Thank you for the opportunity to comment on the short plat of approximately 6 acres into 2 lots, proposed by Laurin Mellergaard [SP-08-00044]. We have reviewed the application and have the following comments.

TO: Community Development Services
FROM: Christina Wollman, Planner II *cw*
DATE: May 18, 2009
SUBJECT: Eagle Crest Short Plat SP-08-00044

Thank you for the opportunity to comment on the Eagle Crest Short Plat, SP-08-00044. Pursuant to the Memorandum of Agreement between Kittitas County and the Washington State Department of Ecology all residential well connections serving the proposed lots shall be required to have meters installed. Metering results shall be recorded in a manner consistent with Kittitas County and Washington State Department of Ecology requirements. The requirement to meter only applies if you rely upon the RCW 90.44.050 exemption from permitting through ecology.

<b>K.C.S.P. NO. 08-00044</b>		
<b>PTN. NE 1/4 OF SEC. 32, TWN. 18N., RGE. 19E., W.M.</b>		
<b>Kittitas County, Washington</b>		
DWN BY <b>G. WEISER</b>	DATE <b>09/09</b>	JOB NO. <b>04635-1</b>
CHKD BY <b>D. NELSON</b>	SCALE <b>1"=100'</b>	SHEET <b>1 OF 2</b>

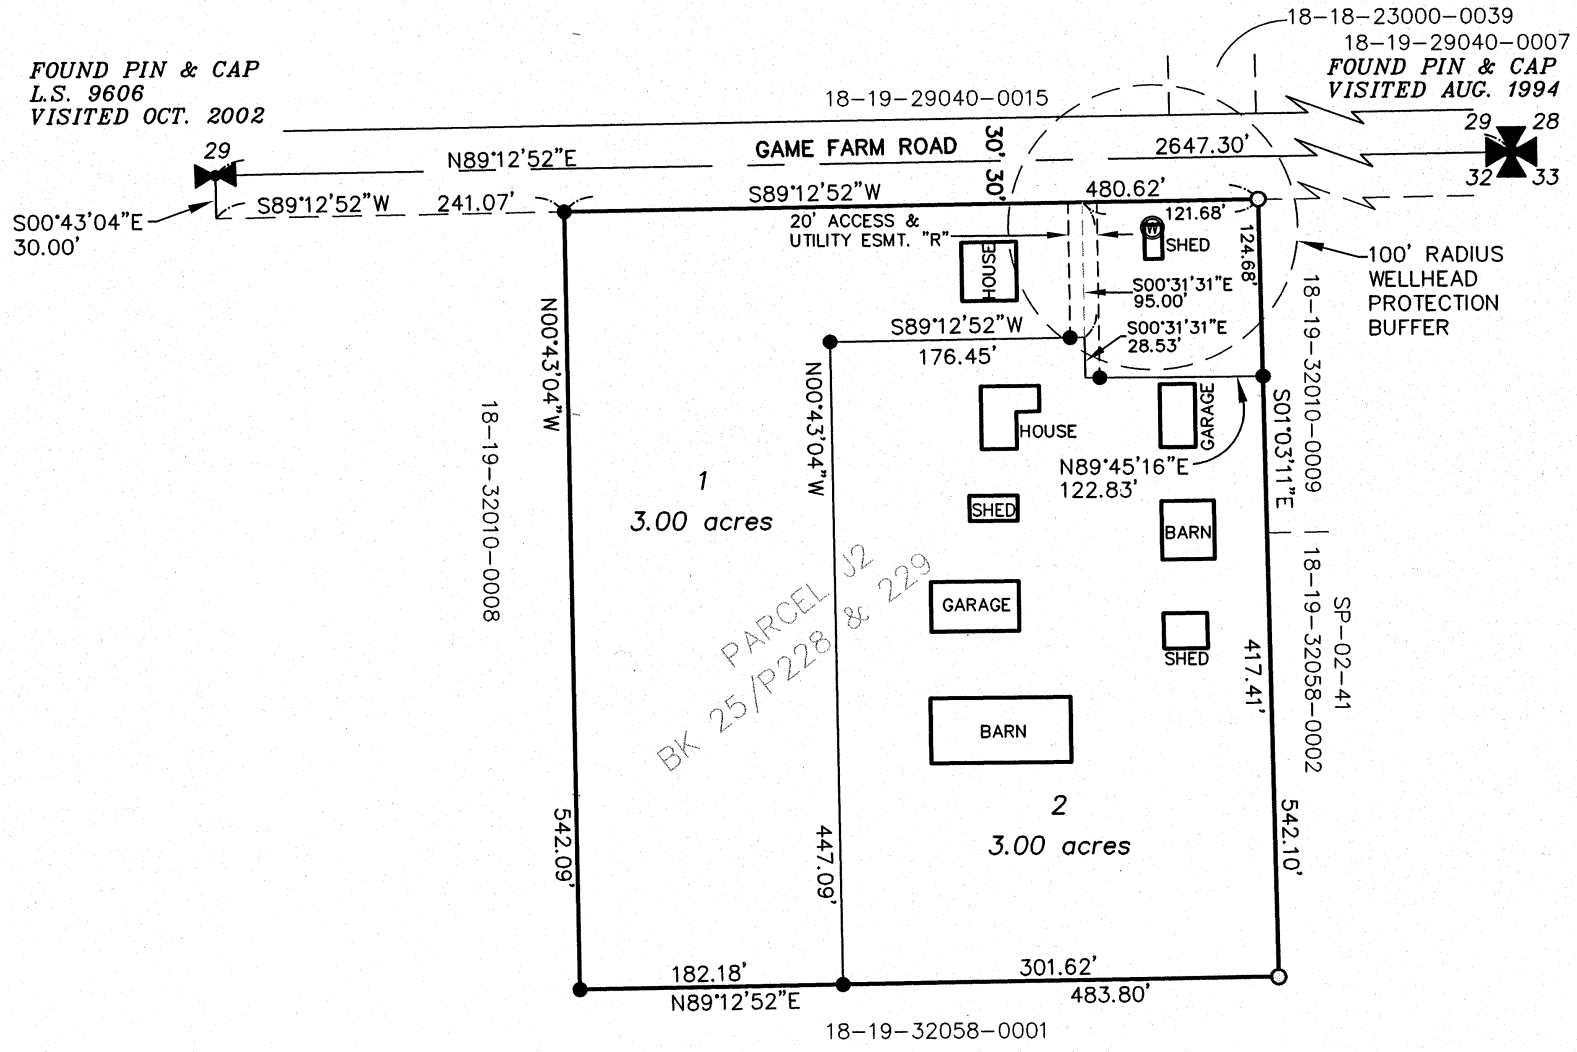
1. Access: The existing driveway shall be used to access the existing houses. The note “to be created by separate document” shall be removed from the 20’ access easement “R” and the 60’ access easement “Q”. If easement “Q” has been recorded, the AFN shall be shown on the plat.
2. Joint-Use Driveway: A joint-use access shall serve no more than two tax parcels. See Kittitas County Road Standards, 9/6/05 edition.
 - a. Access easements shall be a minimum of 20’ wide. The roadway width shall have a minimum width of 12’.
 - b. The surface requirement is for a minimum gravel surface depth of 6”.
 - c. Maintenance of driveway approaches shall be the responsibility of the owner whose property they serve. The County will not maintain accesses.
 - d. Any further subdivision or lots to be served by proposed access may result in further access requirements.
